Your ref H01/0452/02
Our ref GRM/JJM/451/02

REPLACEMENT BUNGALOW, BIJOU, BARRIER BANK, COWBIT.

Description Reduced layout

Drwg.Nos. 451/02/01A and 451/02/02B

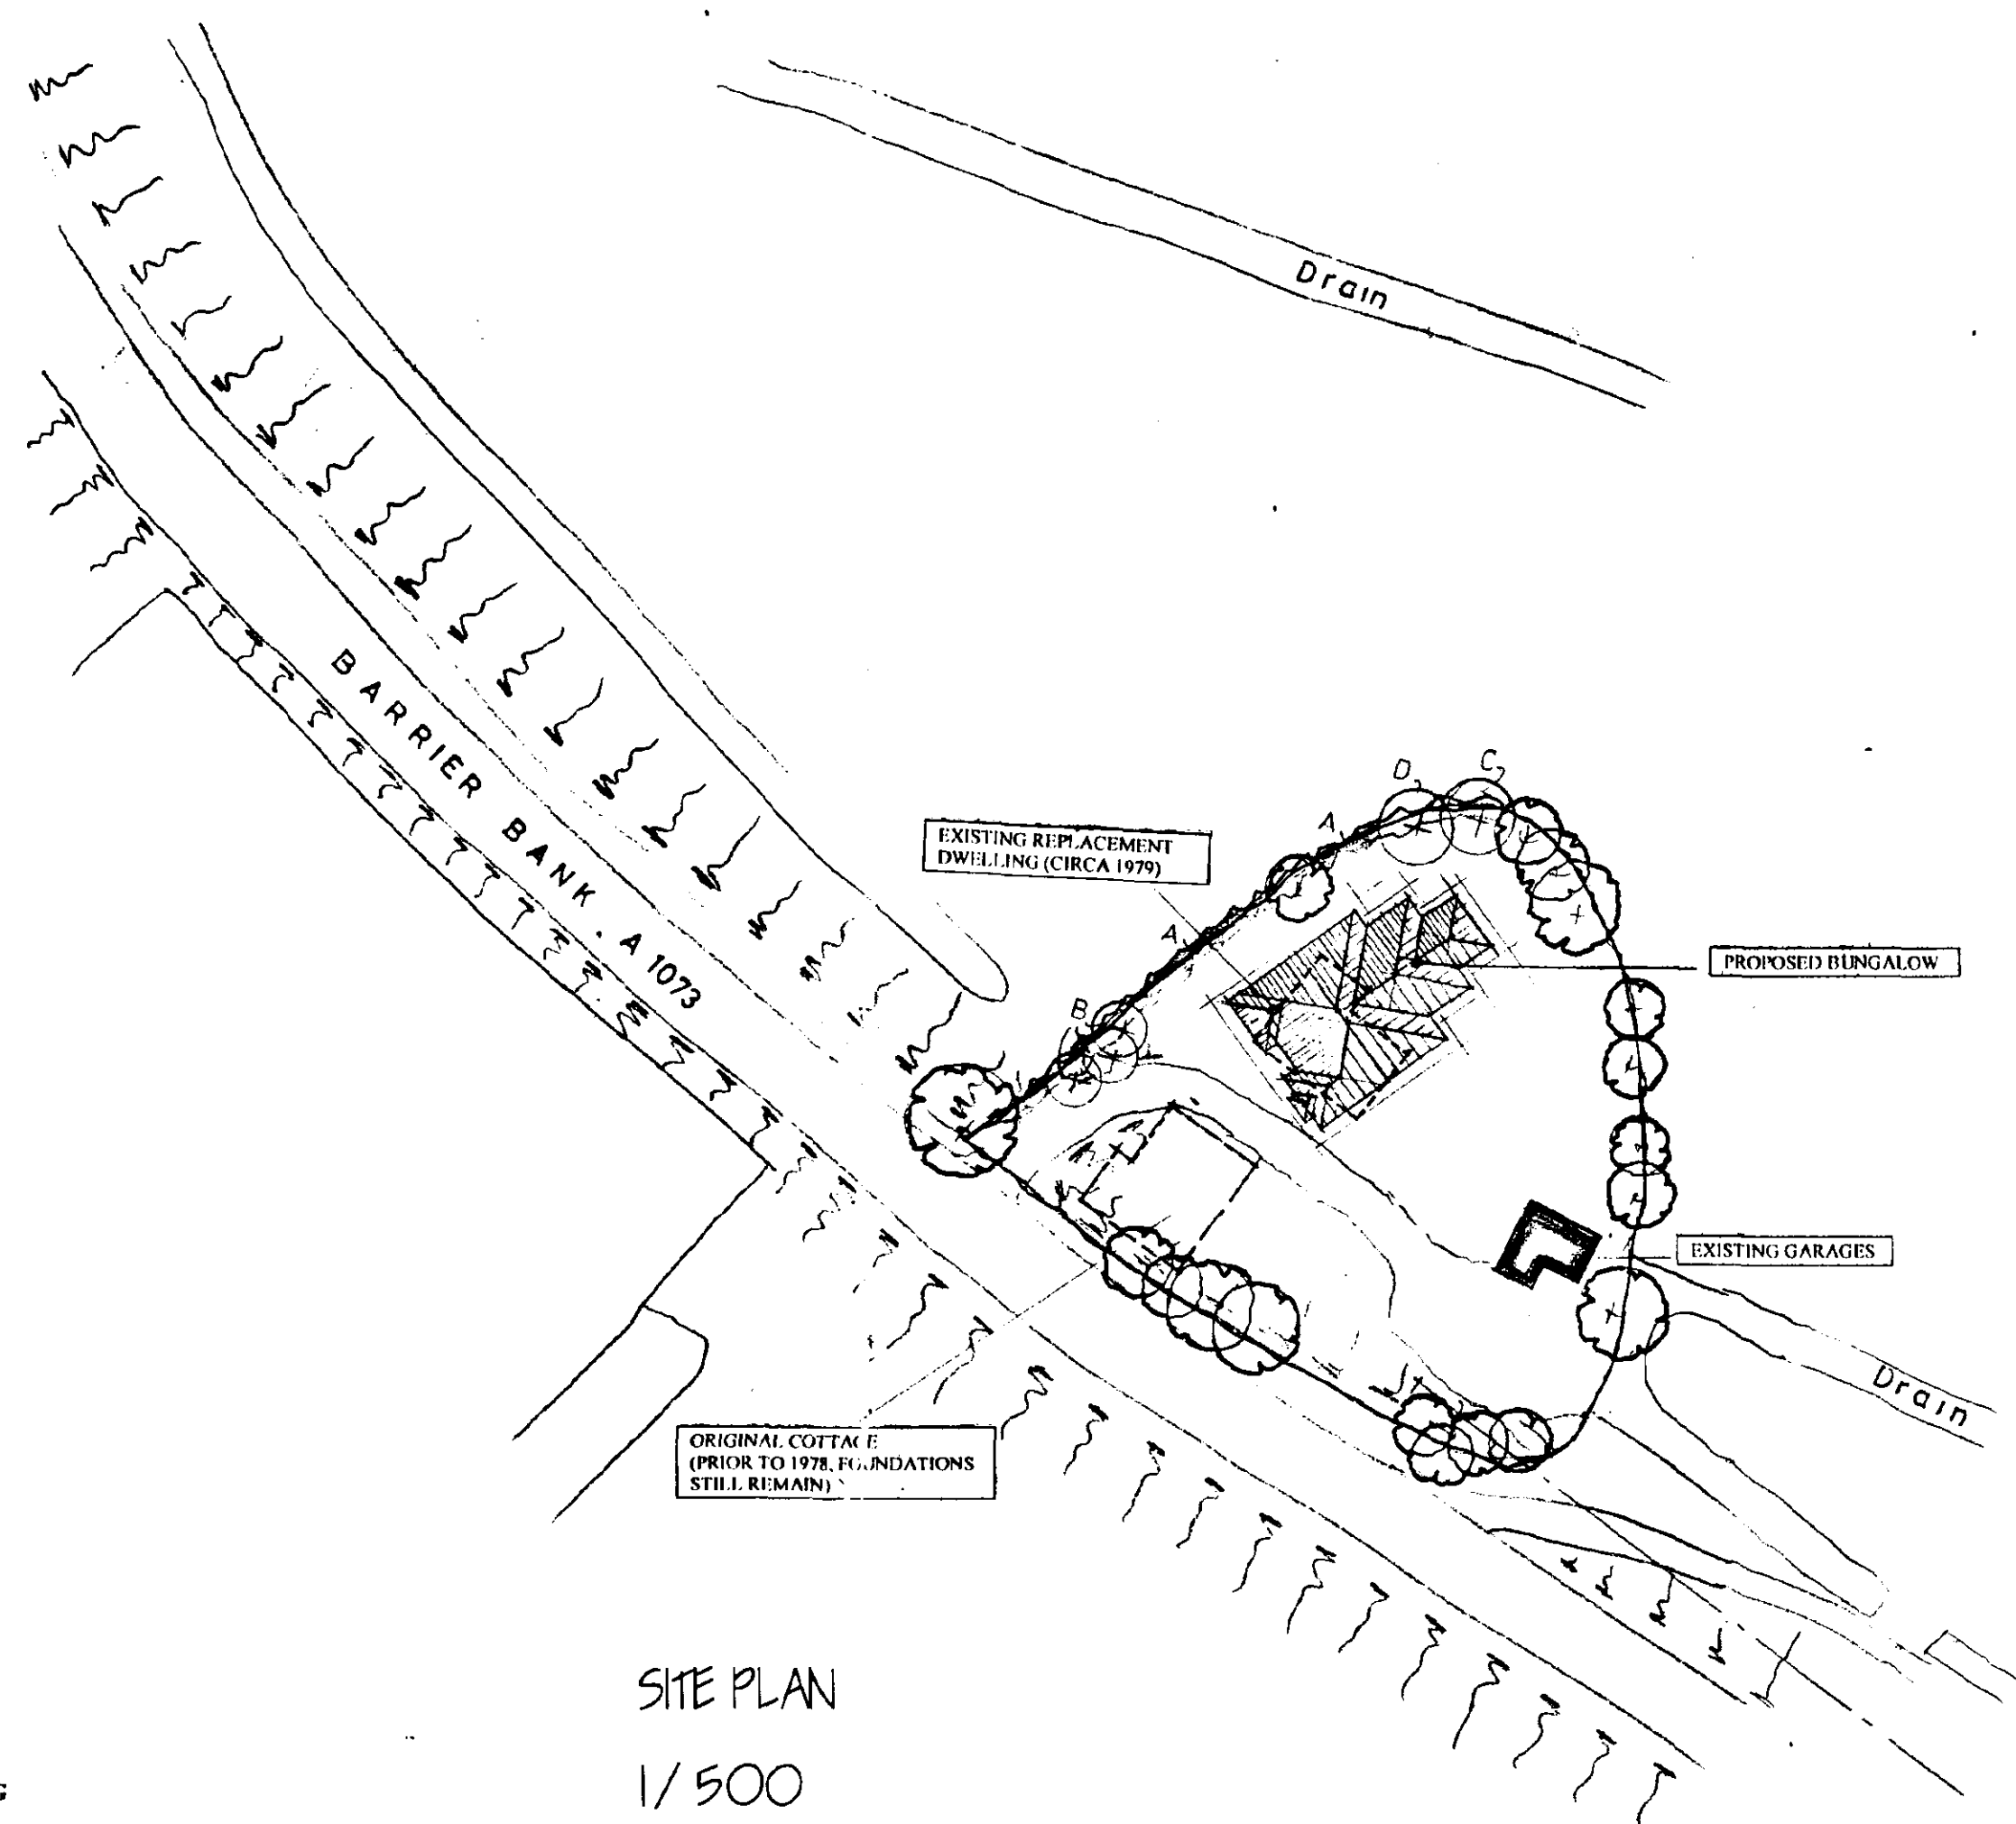
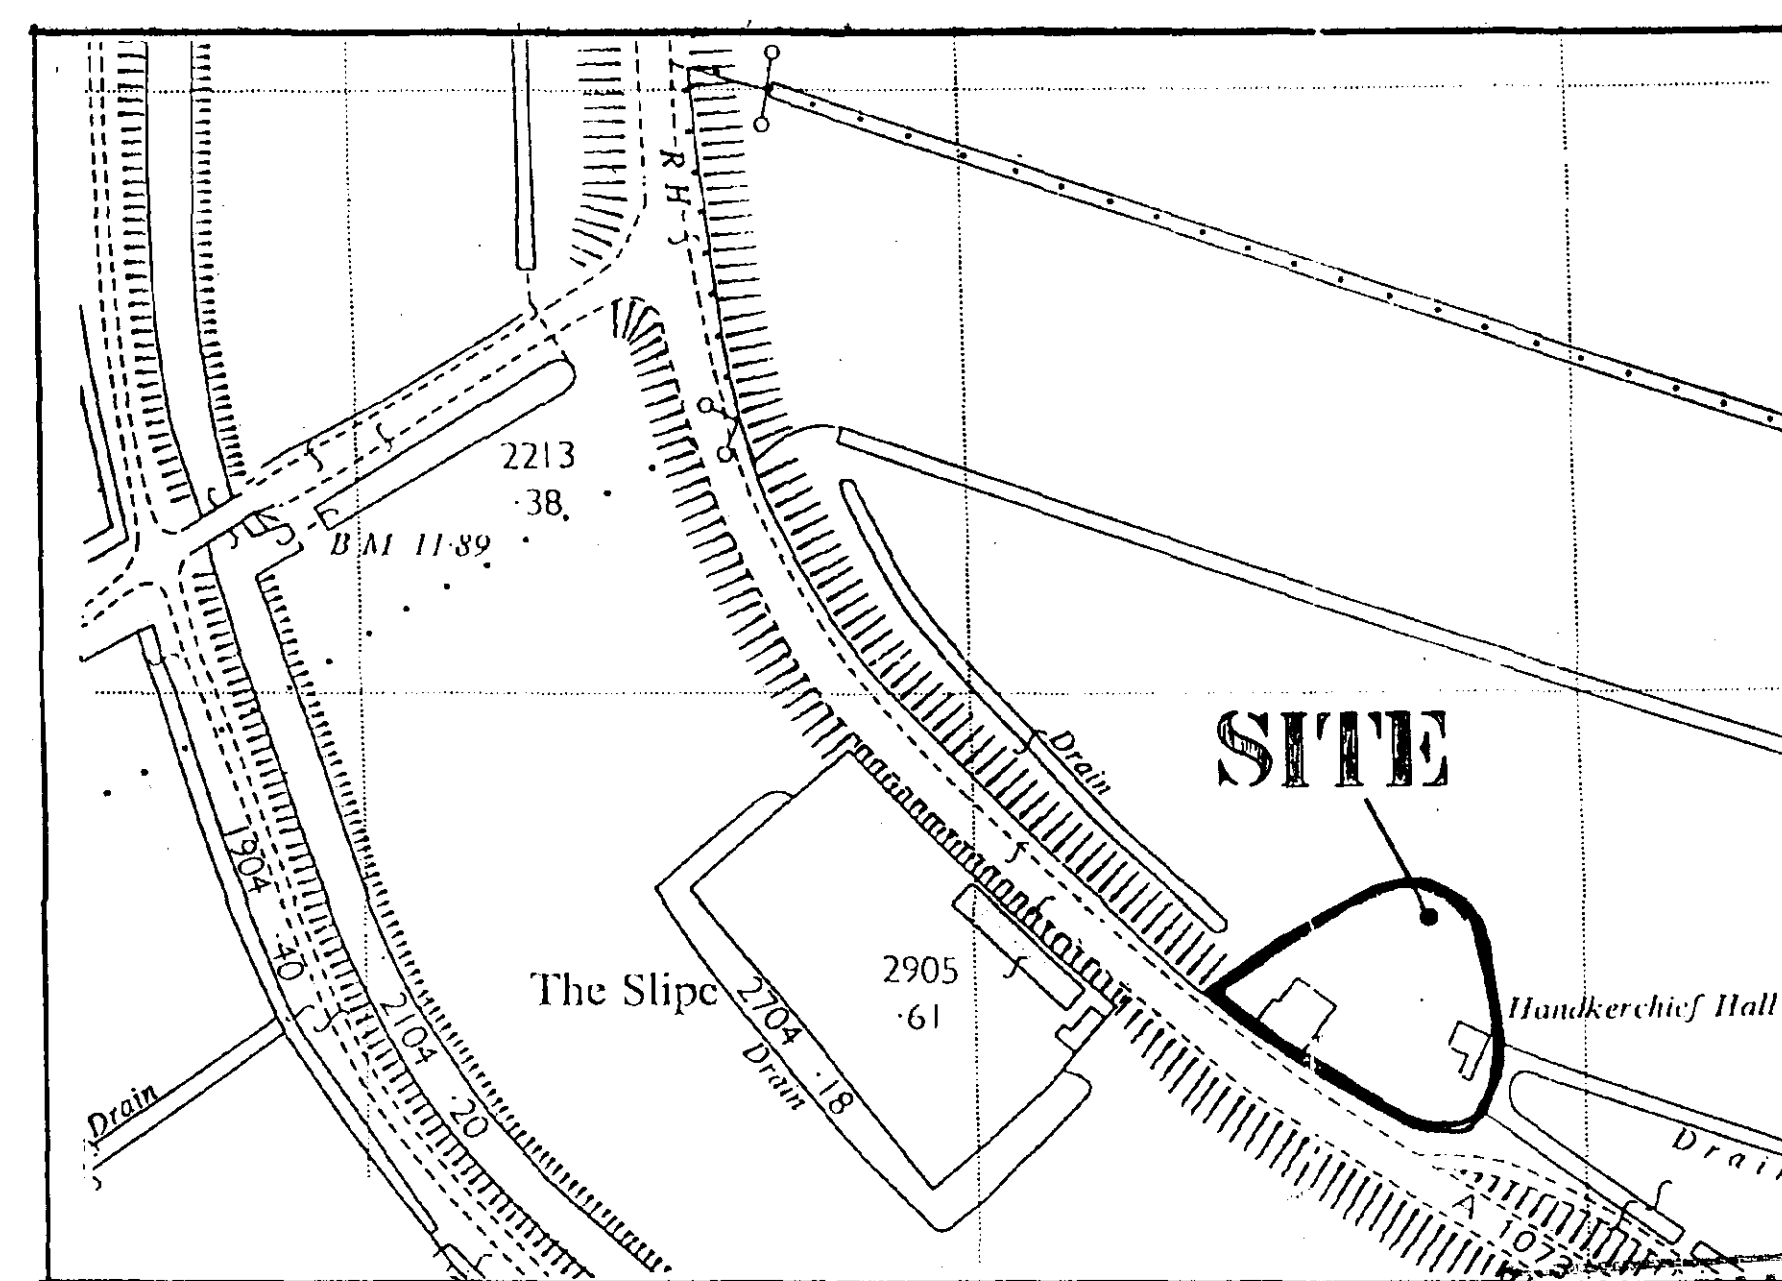
Further to your letter of the 22 July, fax sketches dated 22 August and various discussions, please find enclosed amended (reduced) layout plans as requested.
